WILLOW SPRINGS RANCH FILING NO. 2

CONSTRUCTION DRAWINGS

PCD FILE NO. CDR224

STREET CONSTRUCTION DOCUMENTS FOR:
WILLOW SPRINGS RANCH
FILING NO. 2
BAPTIST ROAD & FOREST LAKES DRIVE
MONUMENT, COLORADO

SHEET: 2 OF 6

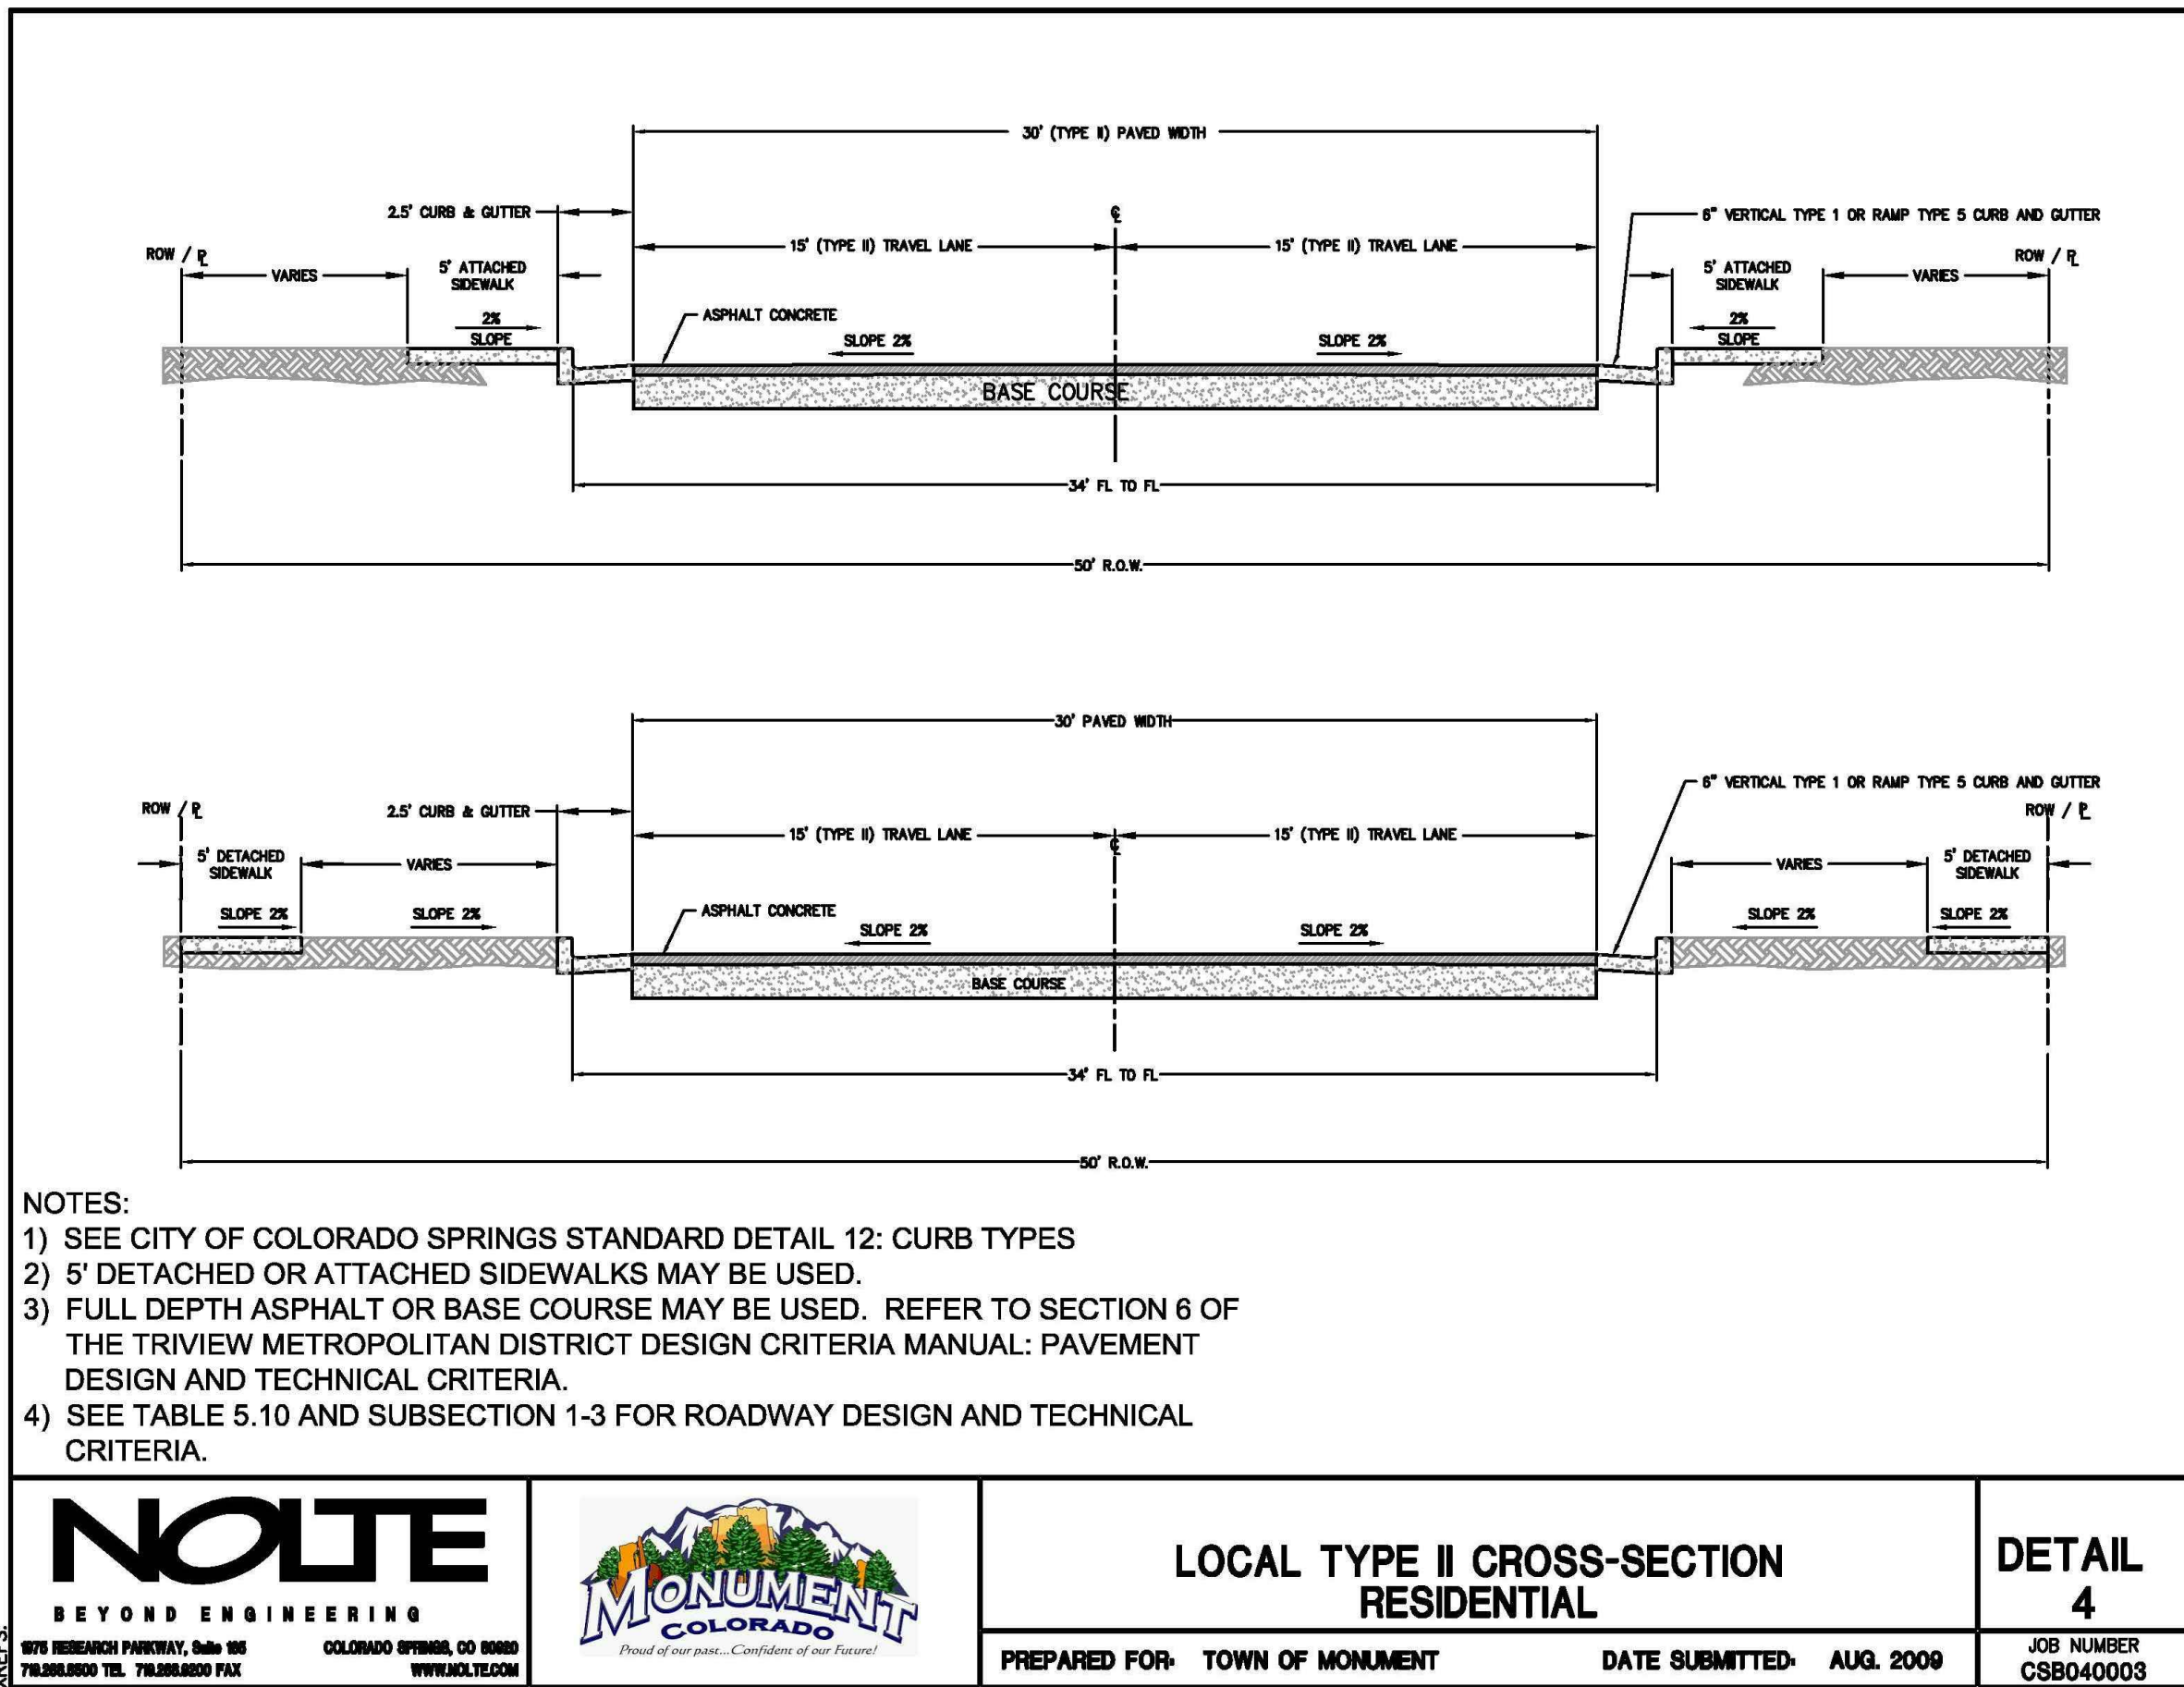
Detail sheet has been modified to replace the Pedestrian ramp details SD_2-40, SD_2-41, and SD_2-42 with the latest version (Revision Date: 6/23/20) to be used for construction of the pedestrian ramps within El Paso County ROW (Forest Lakes Drive).
